THE HILLS SHIRE COUNCIL

15 March 2018

Council received notification on 5 February 2018 of a Section 75W application made to the NSW Department of Planning and Environment to modify a Part 3A approval for a seniors living development at 34-36 Memorial Avenue, Kellyville.

11527
Site Plan Basement - DDA option
1:400B A1
December 2017

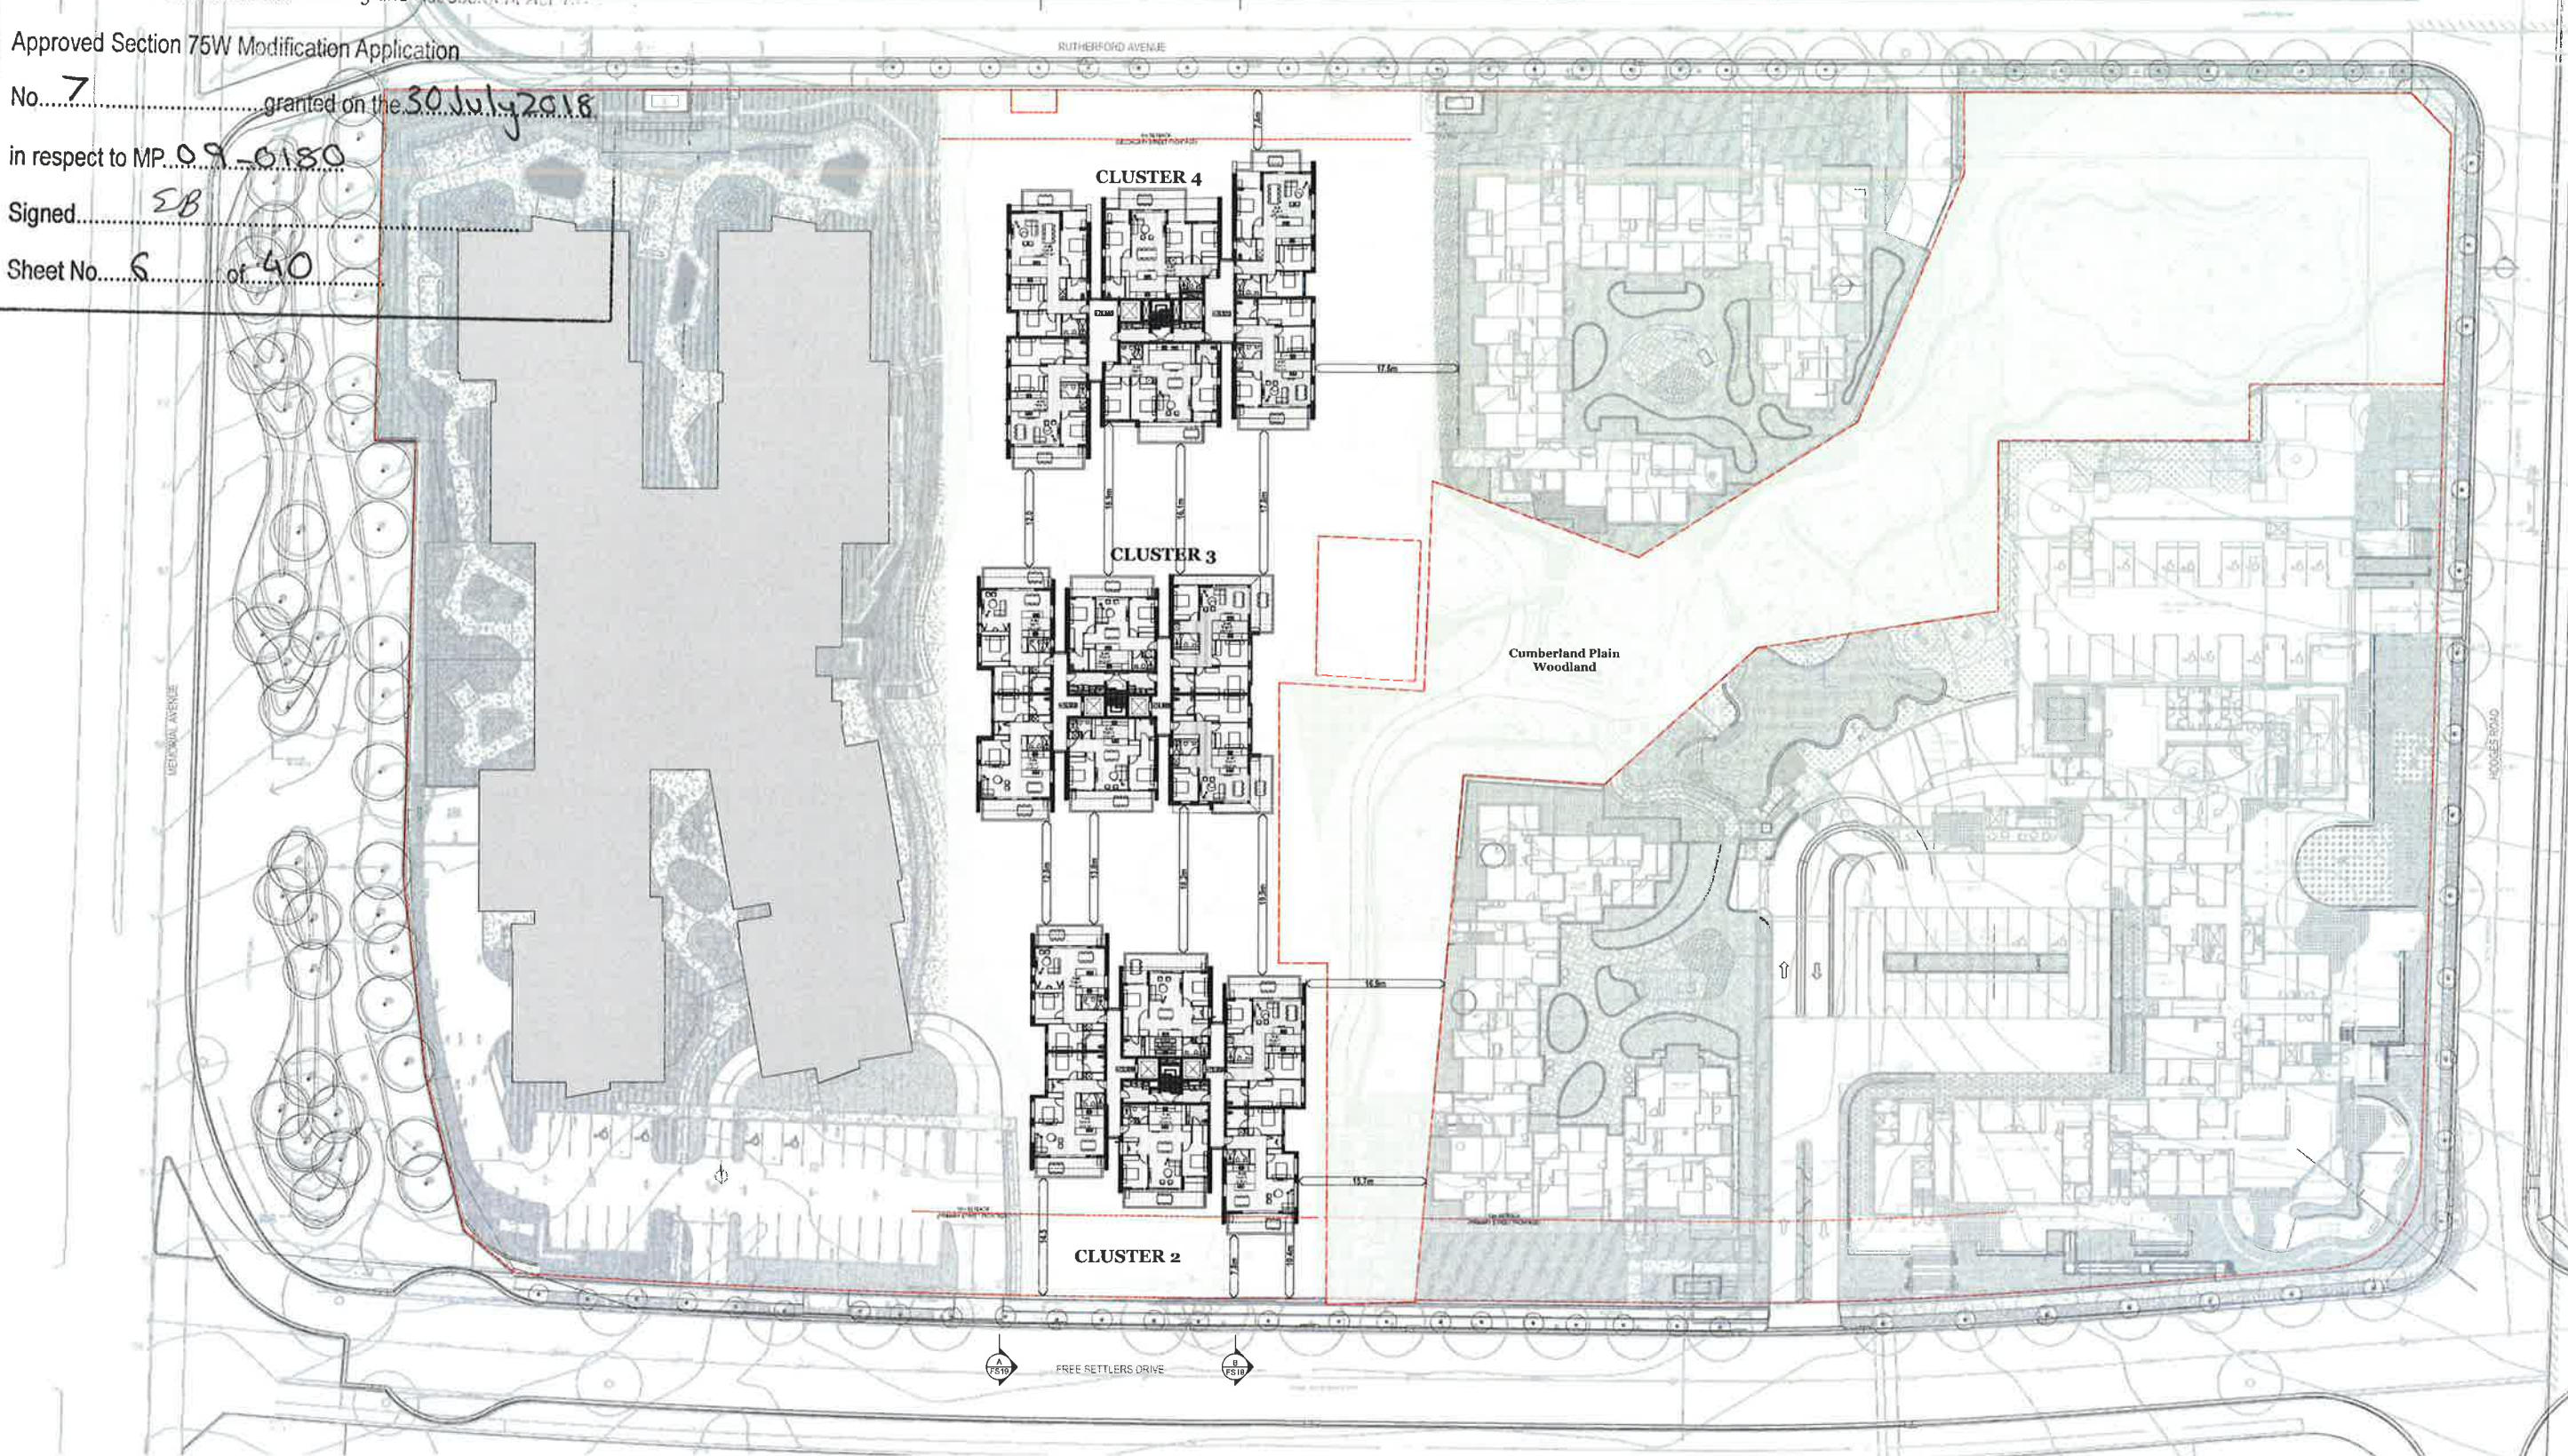
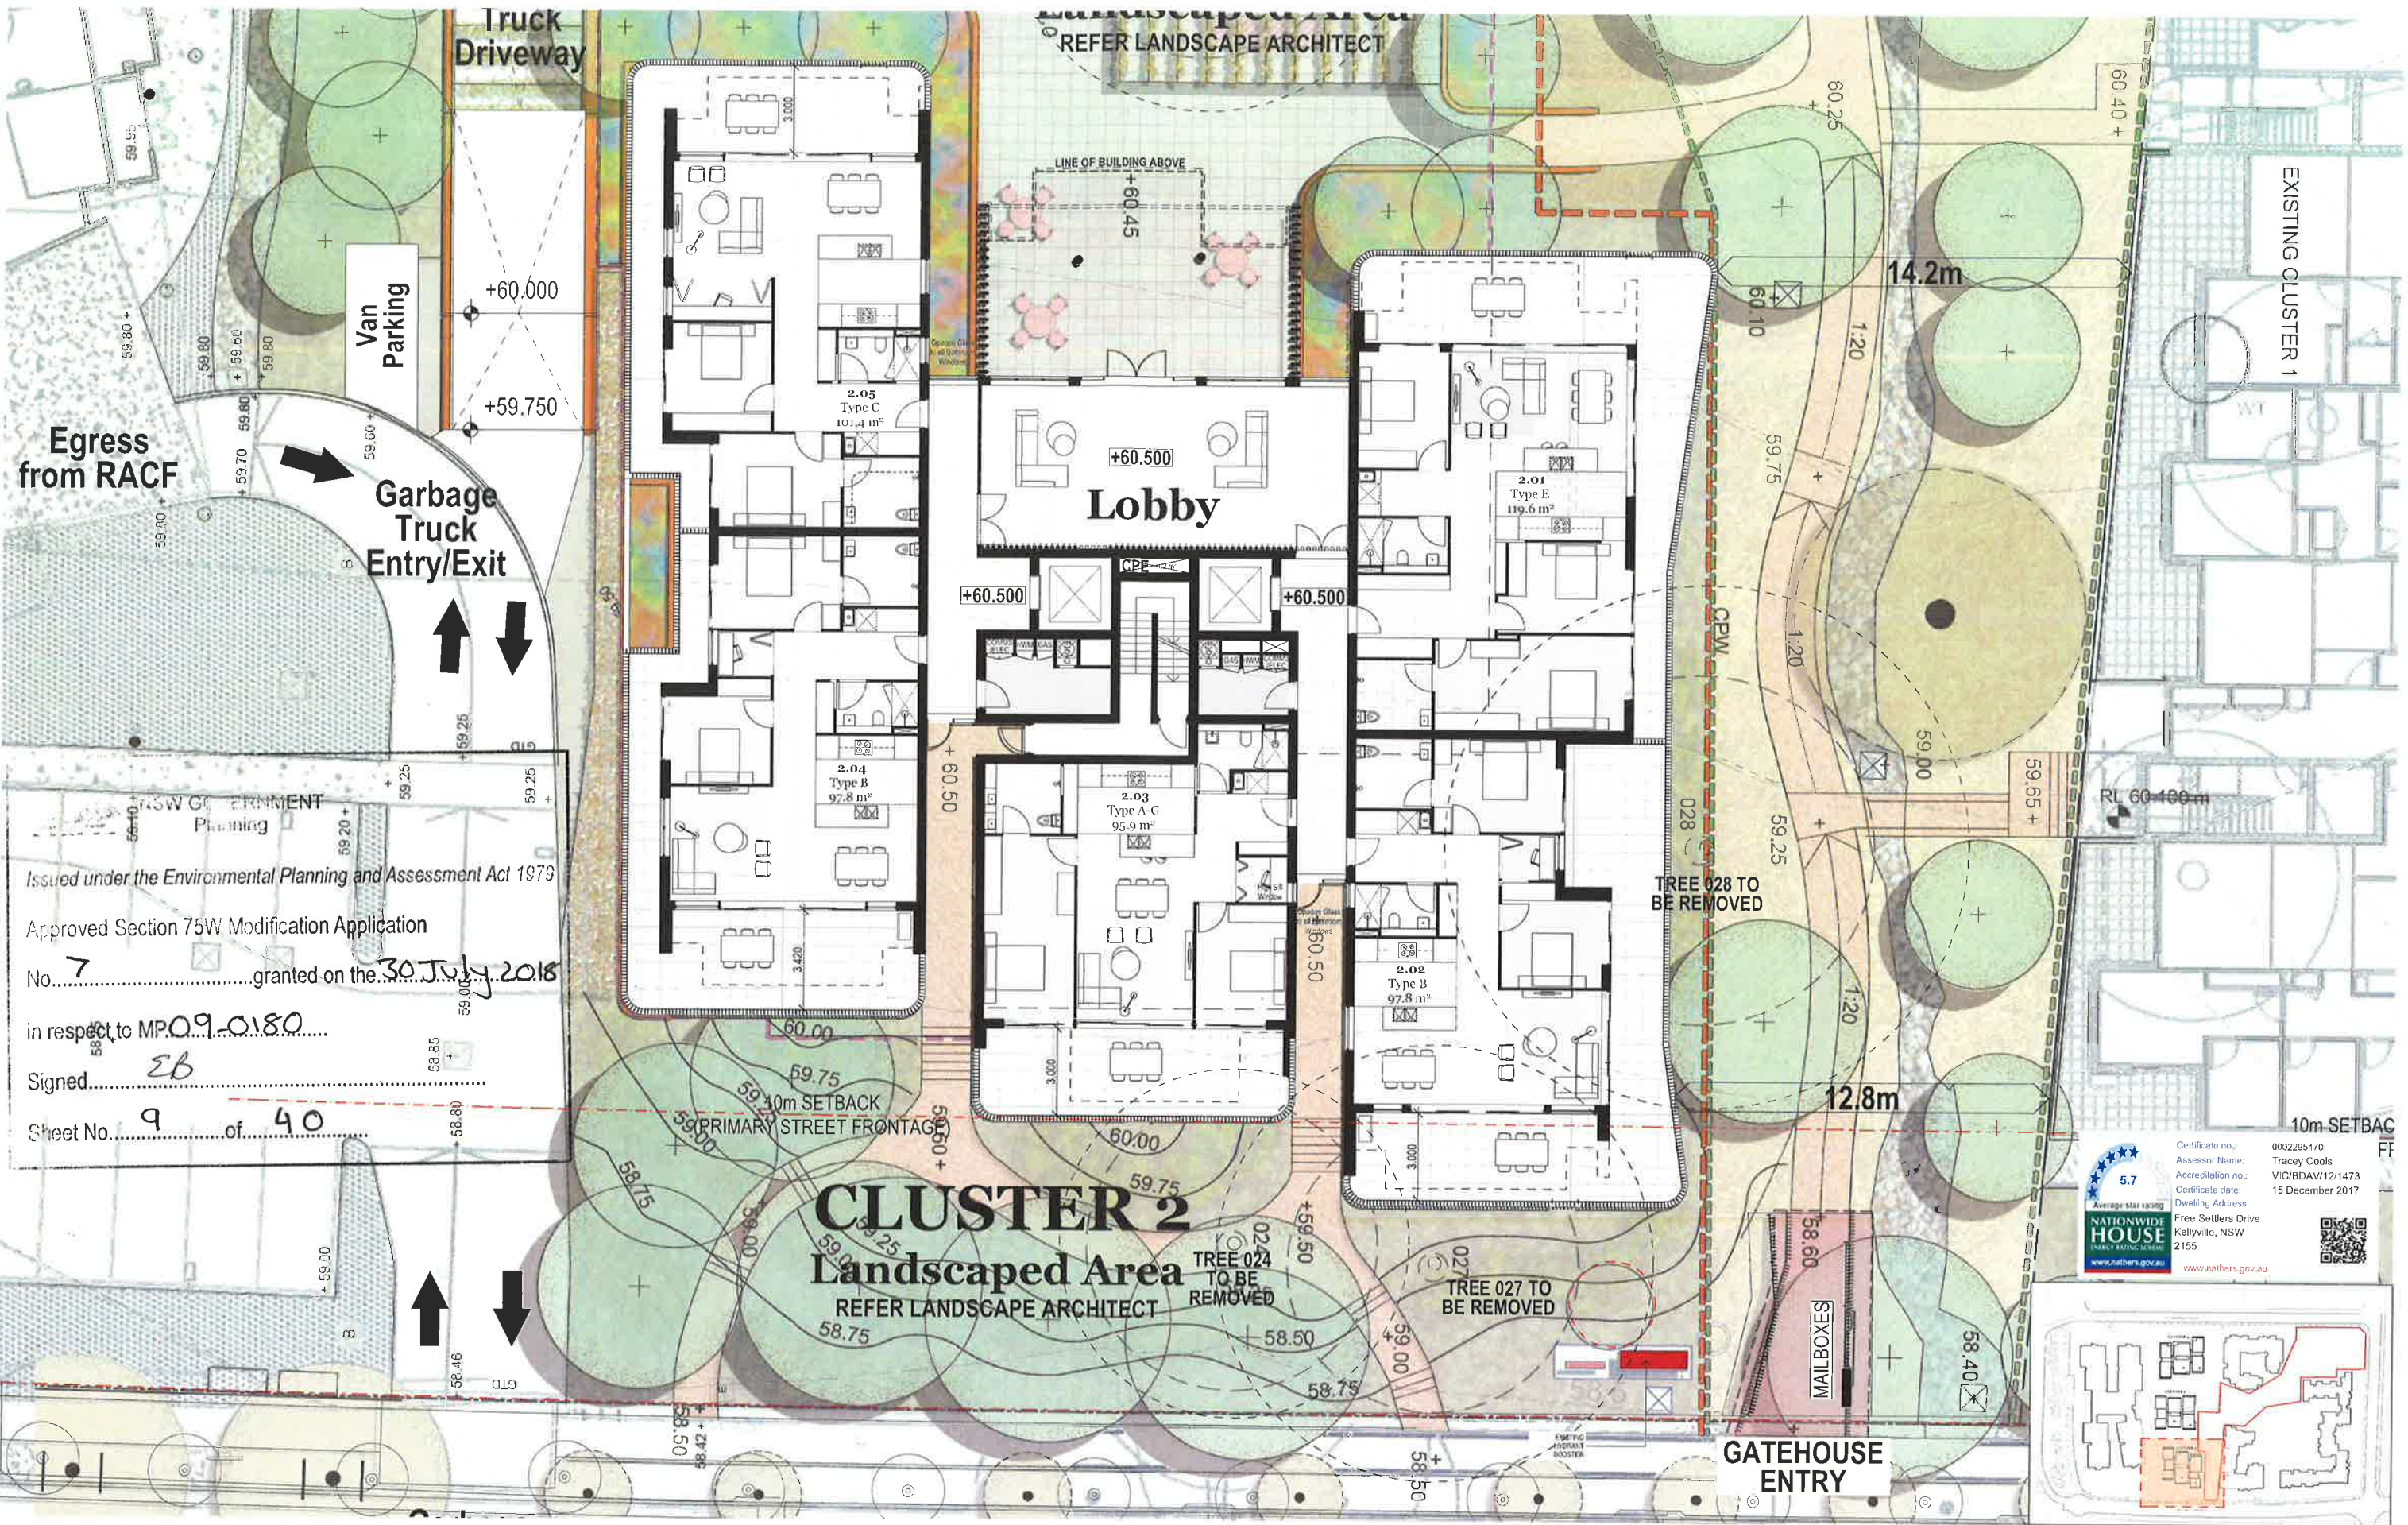
- The blind aisle under Cluster 4 is too long/ non-compliant and needs a dedicated turning space at the end adjacent to the ramp.
- Both ramps have a shutter at the bottom. This means if a vehicle enters the site and is unable to get past the shutter they will need to reverse back up the ramp which is not supported. The shutters need to be more appropriately located or removed (or a dedicated turning area provided in front).

- Disabled space 28 is not located near a lift.
- The development footprint looks to encroach into the Cumberland Plain Woodland restricted development area within the site/ on the property title, created in a previous stage and relied upon as part of the original approval on the site. Any modification will require an amendment to any legal restriction on Title.
